**Planning Department
Transportation Development Services**

December 15, 2015

**Re: ABQ Moving and Storage Paving Plan
5001 Paseo Del Norte NE
Traffic Circulation Layout
Engineer's/Architect's Stamp dated 12-8-15 (C17-D124)**

VICINITY MAP C-17 NTS

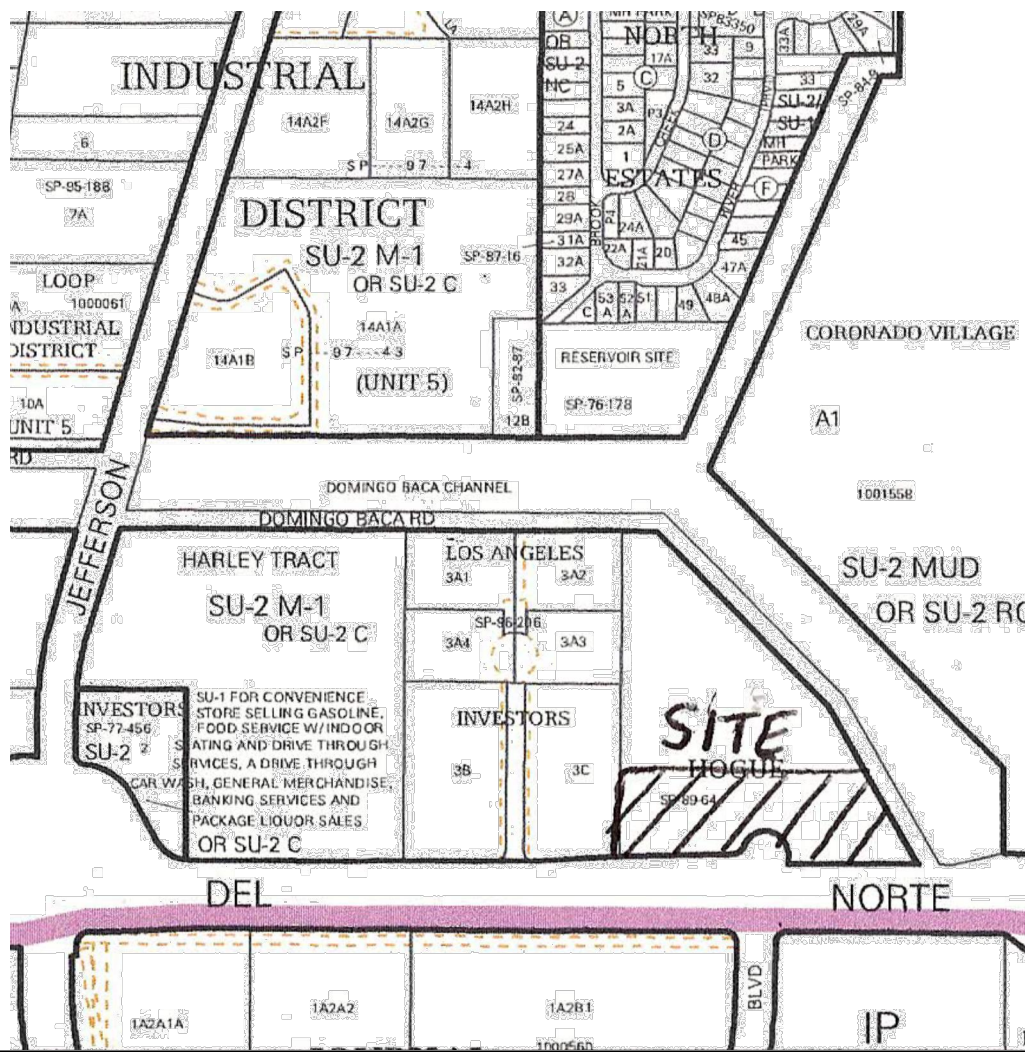
1. Please show a vicinity map showing the location of the development in relation to streets and well known landmarks.
2. Please identify all existing doors, sidewalks, curbs, walls and anything that influences the parking and circulation on the site.

H/C PARKING SIGN

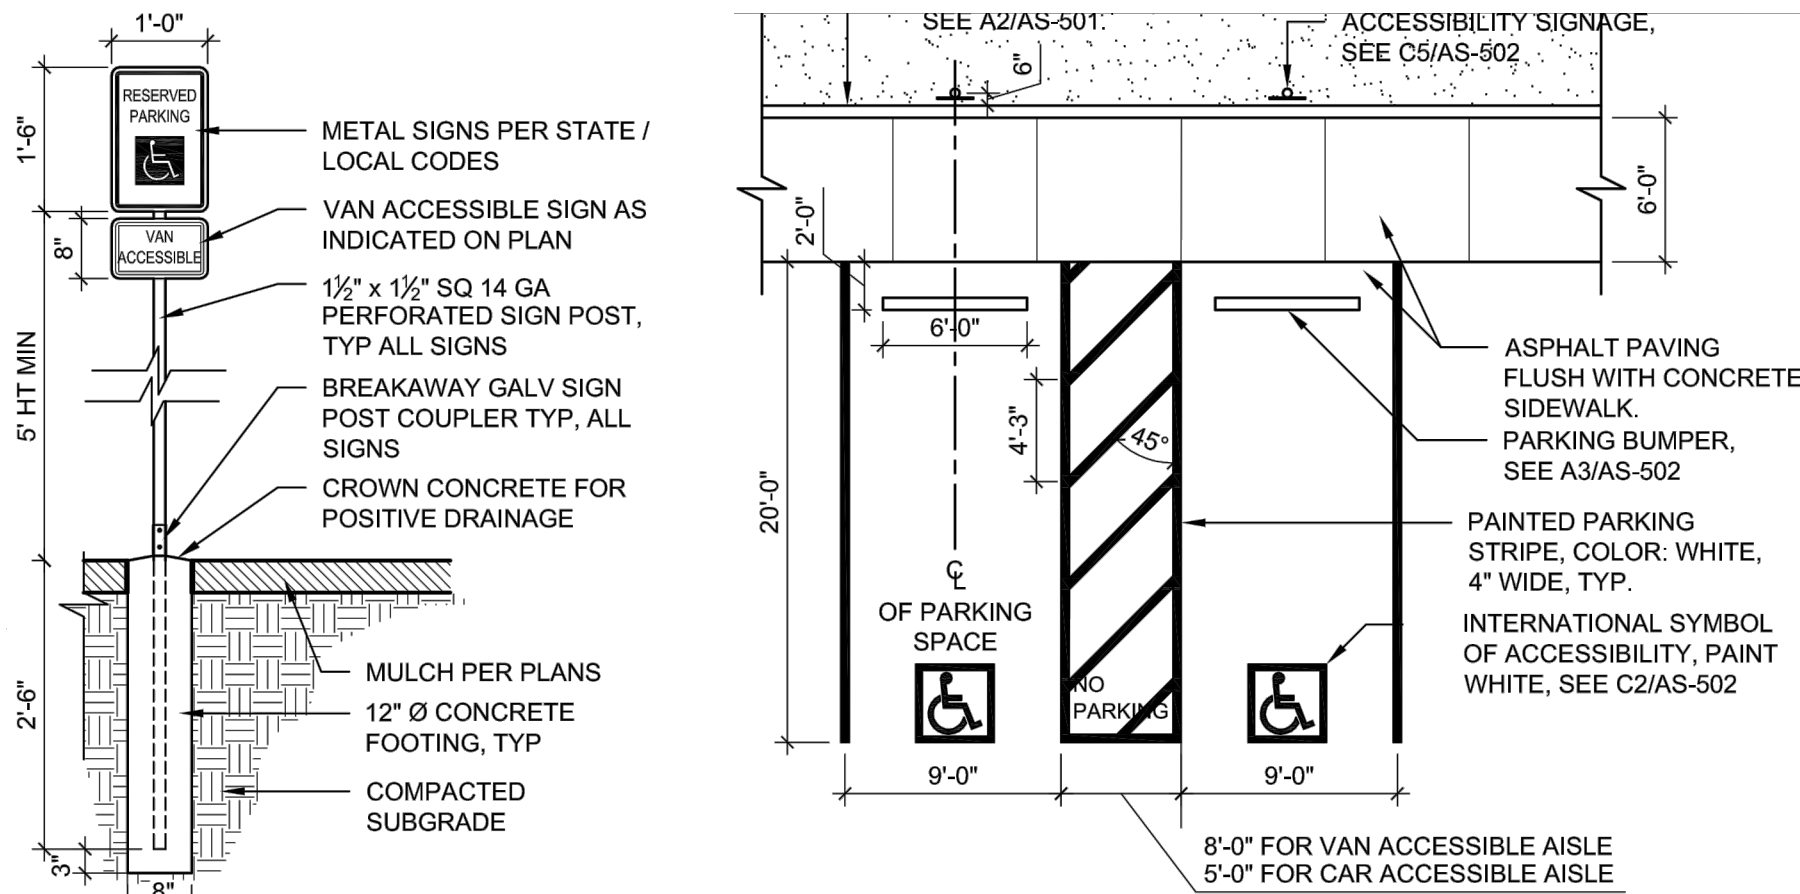
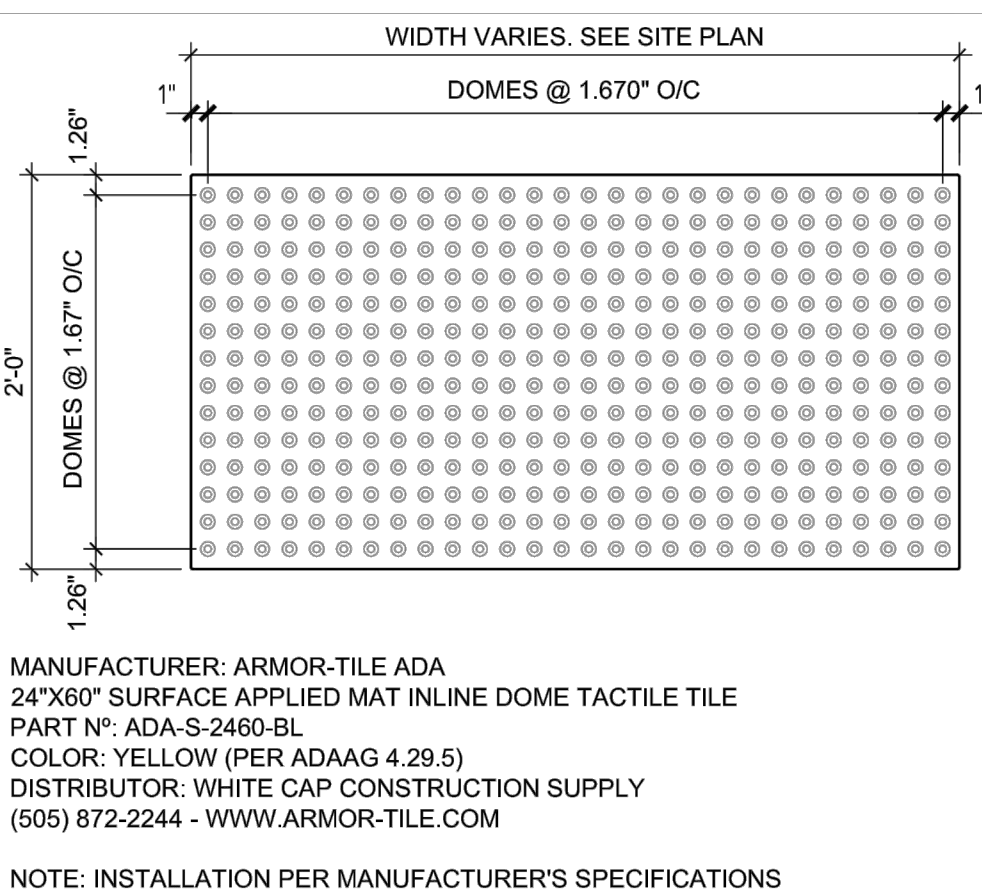
6. The ADA accessible parking sign must have the required language per 66-7-352.4C NMSA 1978 **"Violators Are Subject to a Fine and/or Towing."** Please show detail of handicap parking signs.

7. The ADA access aisle shall have the words **"NO PARKING"** in capital letters, each of which shall be at least one foot high and at least two inches wide, placed at the rear of the parking space so as to be close to where an adjacent vehicle's rear tire would be placed. (66-1-4.1.B NMSA 1978)

PARKING LOT LAYOUT PLAN

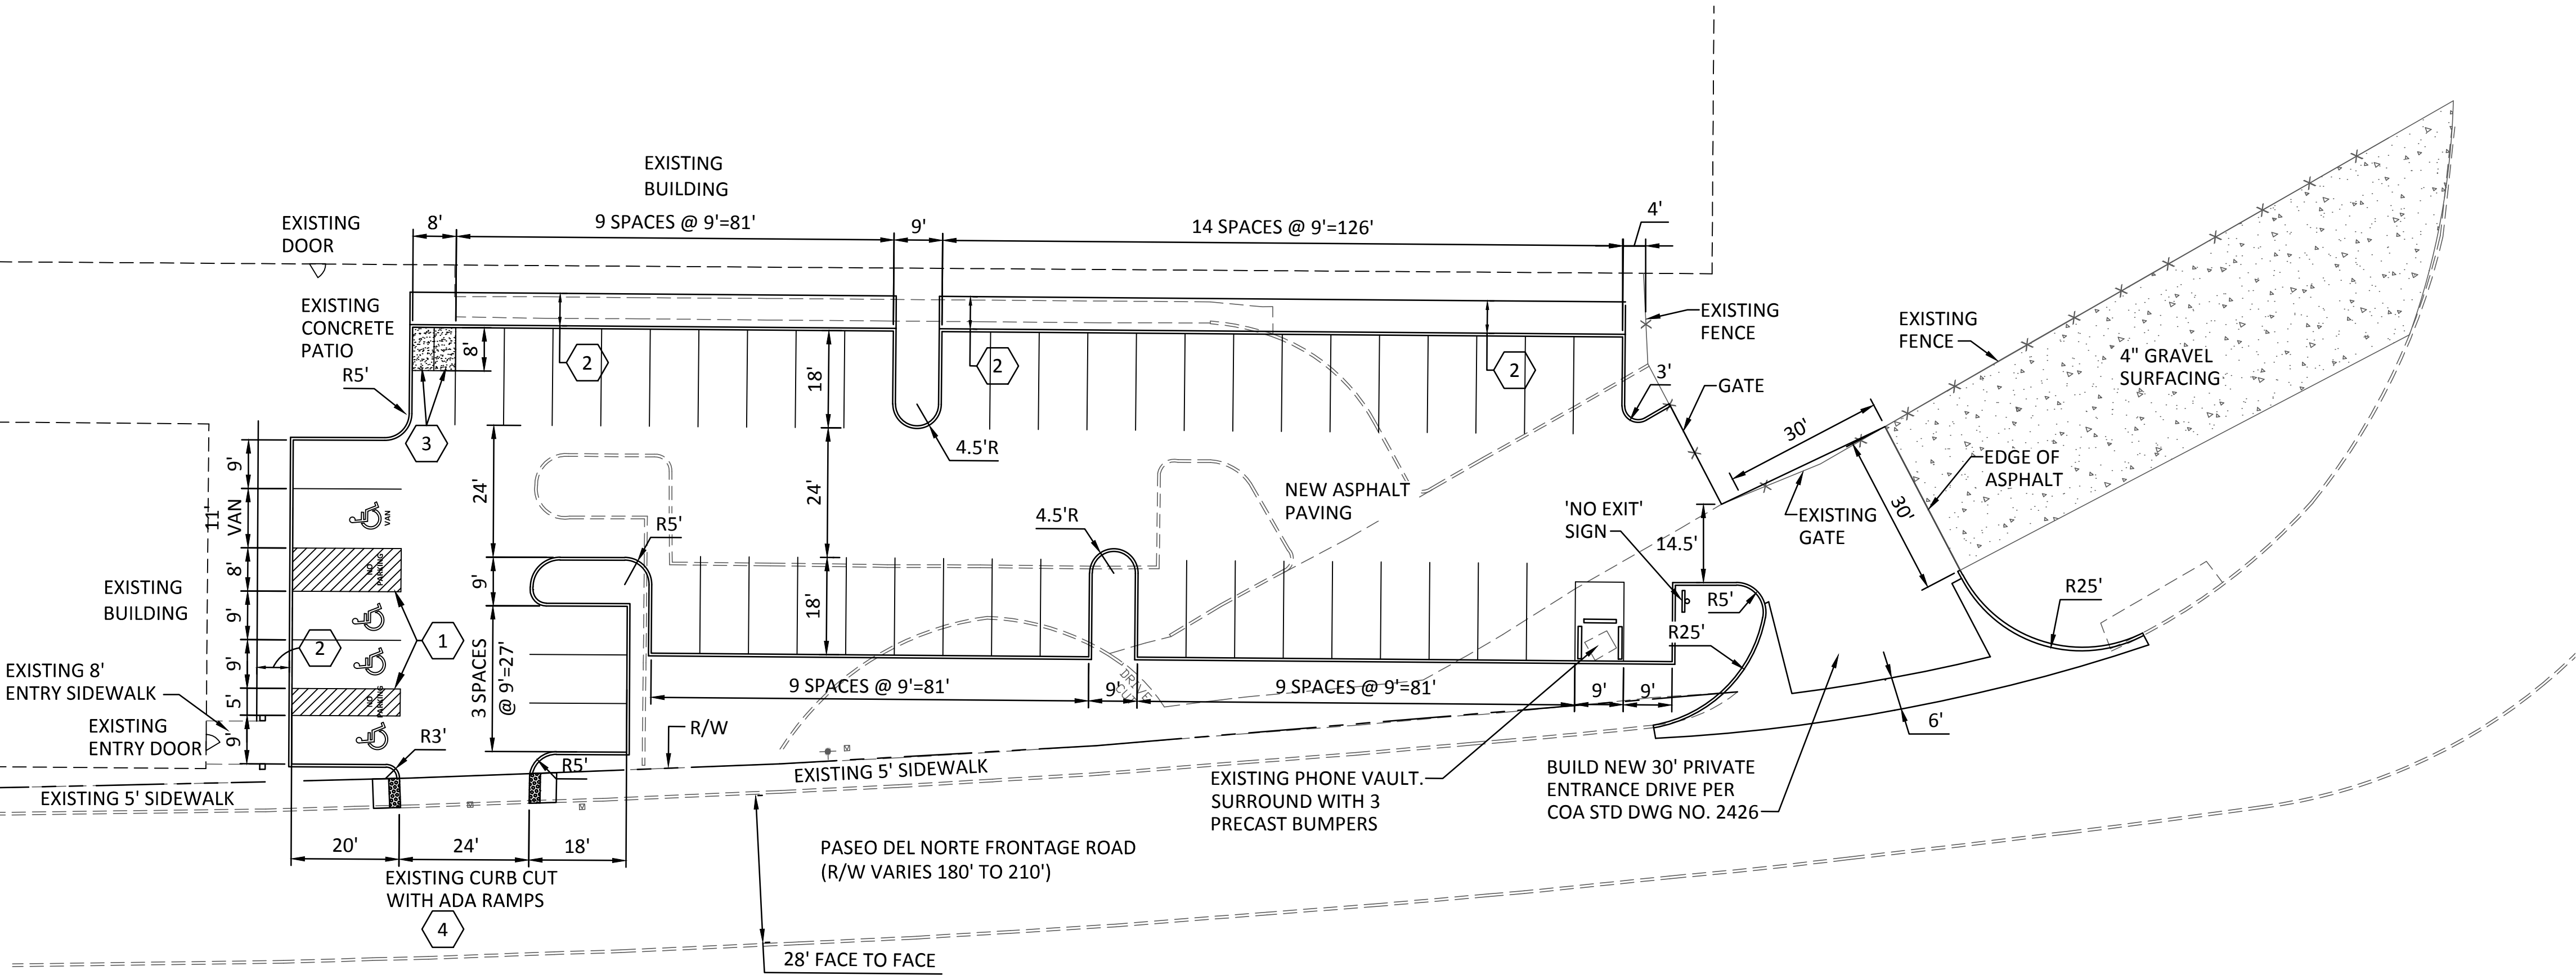
3. Identify all existing access easements and rights of way with dimensions. Please detail proposed new sidewalk with ADA ramps on Frontage Rd. Call out appropriate COA standard drawings.

4. Identify the right of way width, medians, curb cuts, and street width on Frontage Rd.
5. Please list the width and length for all motorcycle parking spaces.

8. Per the DPM, a 6 ft. wide ADA accessible pedestrian pathway is required from the public sidewalk to the building entrances. Please clearly show and detail this pathway from Frontage Rd.

9. Per the DPM, a 6 ft. wide ADA accessible pedestrian pathway is required from the HC parking stall access aisles to the building entrances. Please clearly show this pathway to the entrances of the existing buildings.
10. Please include two copies of the traffic circulation layout at the next submittal.
